DECISION DELEGATED TO HEAD OF PLANNING

Application No: H14-0821-24 **Applicant:** Neil Brown Engineering Ltd

Proposal: Erection of 11 industrial units (Use Classes E(g), B2 and B8) - Approved under H14-0221-21. Modification of Condition 2 to allow amendments to previously approved plans

Location: Land Adjacent To Neil Brown Engineering Ltd Benner Road Pinchbeck

Proposed Site Plan

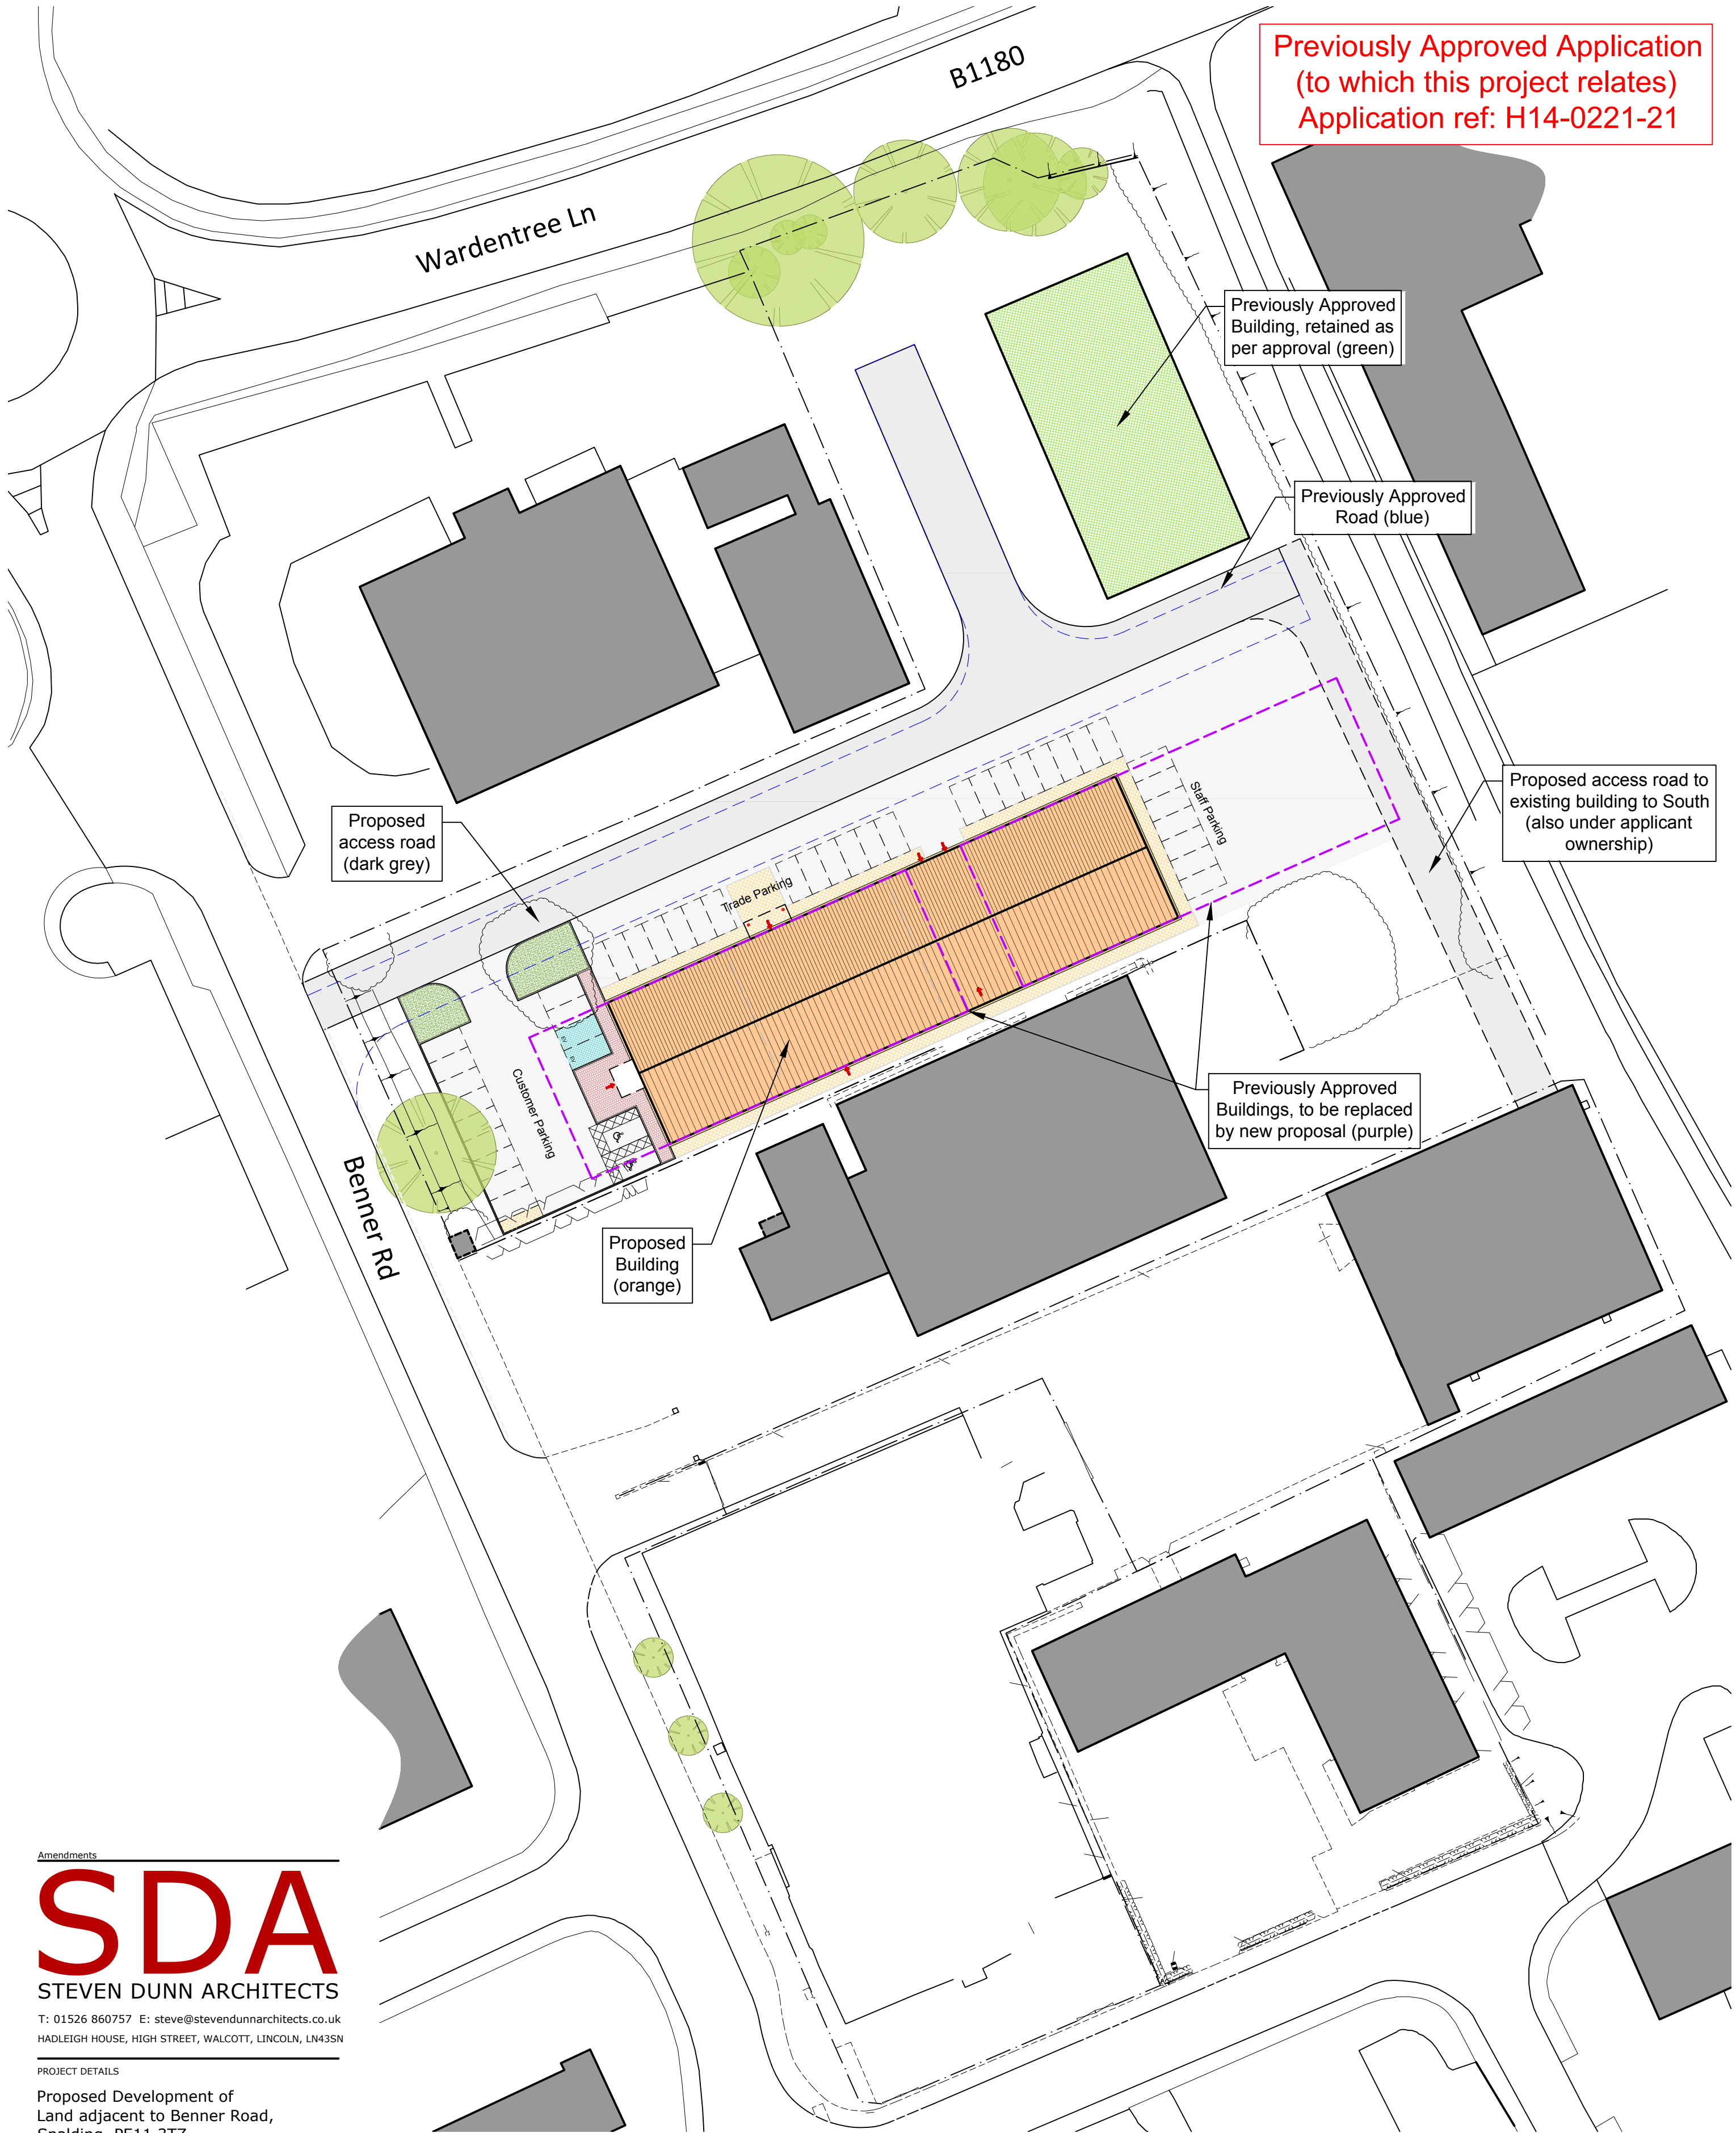
The position of the access road has been altered slightly from the approved plans. One of the three units previously approved is to remain in situ. Of the two remaining buildings as approved, instead of two buildings being retained and separated, one larger continuous structure is proposed, with associated alterations to parking.

The proposed scheme has, for the proposed single enlarged shed, 21 car parking spaces for Trade, 7 staff parking spaces along the eastern side, and 13 customer car parking spaces plus 2 disabled spaces. This doesn't affect the spaces for the unchanged block. The proposed scheme has more parking as a result to the previously approved 2 sheds.

In terms of cycle parking, 12 covered cycle parking spaces were shown on the scheme previously. Cycle parking is considered necessary as the Policies Map indicates a cycle route is suggested along the front of the site. It is therefore suggested that a condition is imposed requiring the 12 covered cycle parking spaces to be provided.

A further condition is suggested in the new decision notice which requires the 12 cycle parking spaces to be provided on site. These were previously shown on drawing 1309-1_1_PL_SP01 which has been omitted from the new decision notice as the layout has changed and the revised layout is shown on drawing x which does not include the cycle parking previously shown. Condition 2 no longer contains drawing 1309-1_1_PL_SP01 and therefore the condition is necessary in order to secure the required cycle parking, now that a new layout has been agreed.

DATE	DRAWN
June 2024	E.B
SCALE	DRNG No.
1:100 @ A2	2772-A2-01a

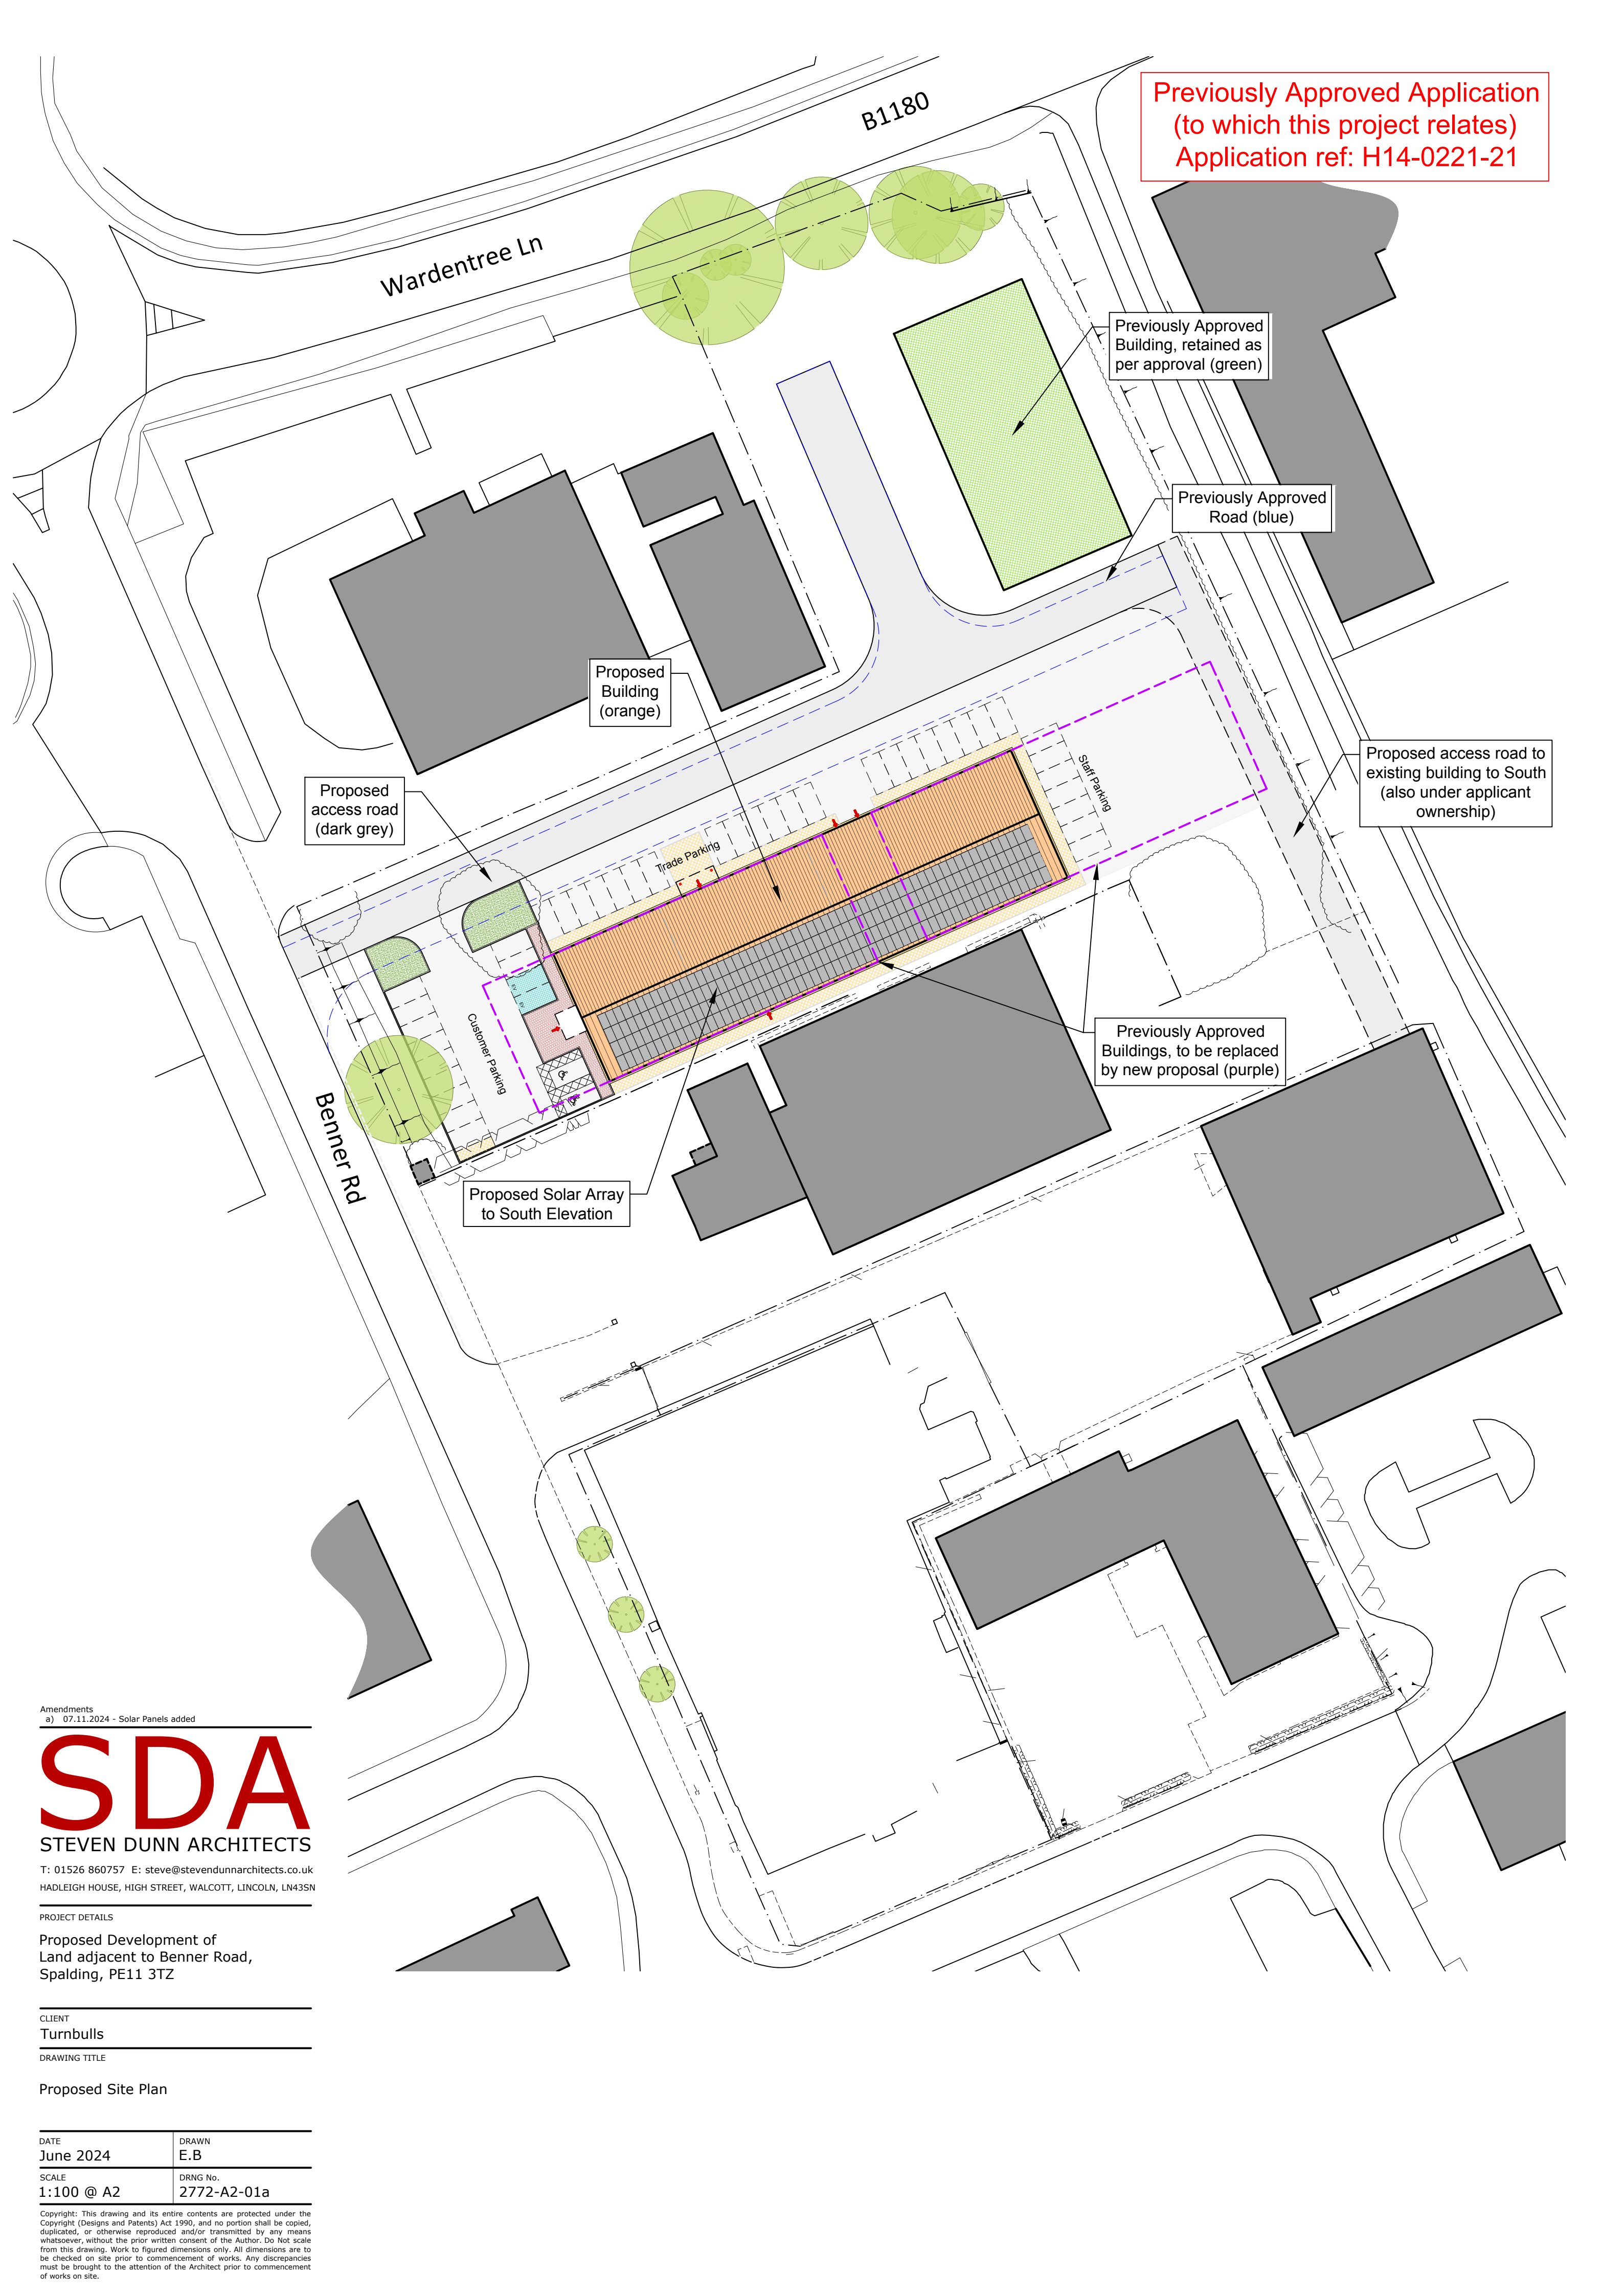
The proposals include solar panels along the southern roof element of the structure and as such this is an improvement in climate change terms compared with the approved scheme.
